CITY OF ALBUQUERQUE

**RE: Pacific Mutual Door and Window - Tract 1, Lands of L.A.
Paving, Grading & Drainage Plan
Engineer's Stamp Date 4-11-2014 (File: C17D005)**

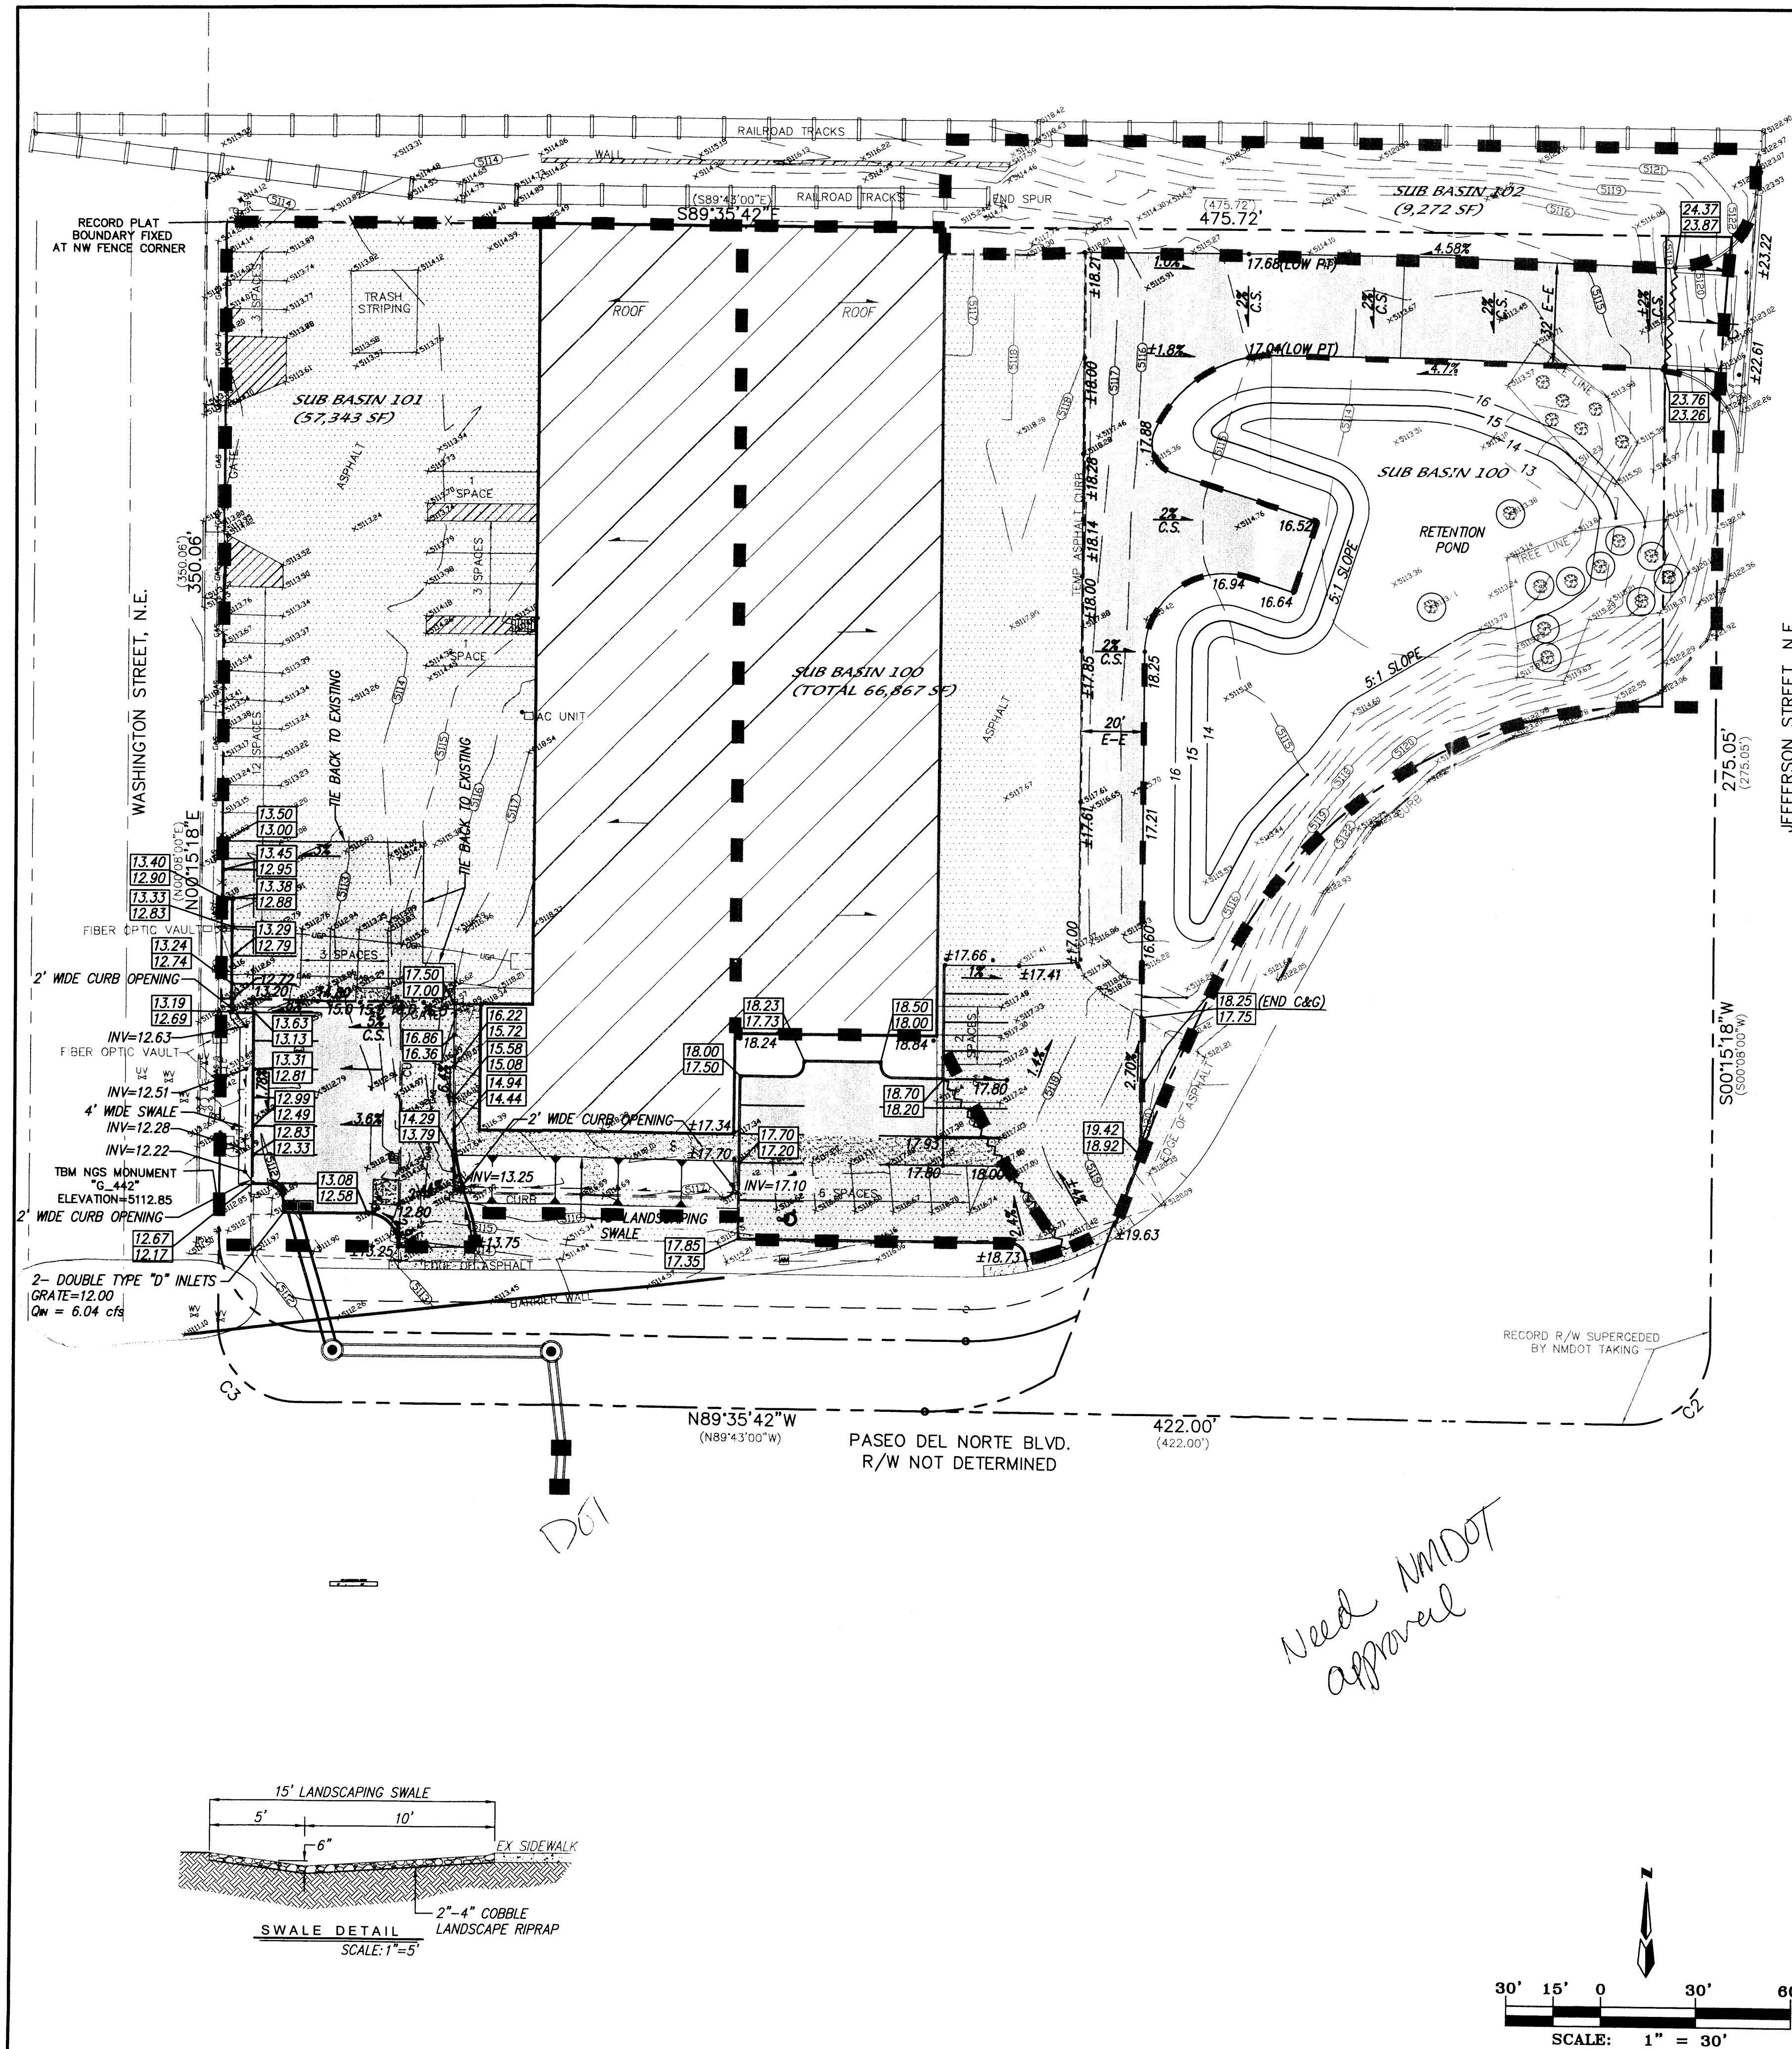
1. Since the property abuts NMDOT easements and is draining into NMDOT infrastructure, NMDOT approval is a prerequisite for Grading and Paving Permit approval.

Since the disturbed area on this site exceeds 1.0 acre, an Erosion and Sediment Control (ESC) Plan, prepared by a NM PE and approved by the City's Stormwater Engineer, will be required for this site, prior to Hydrology approval of a Building Permit or Work Order.
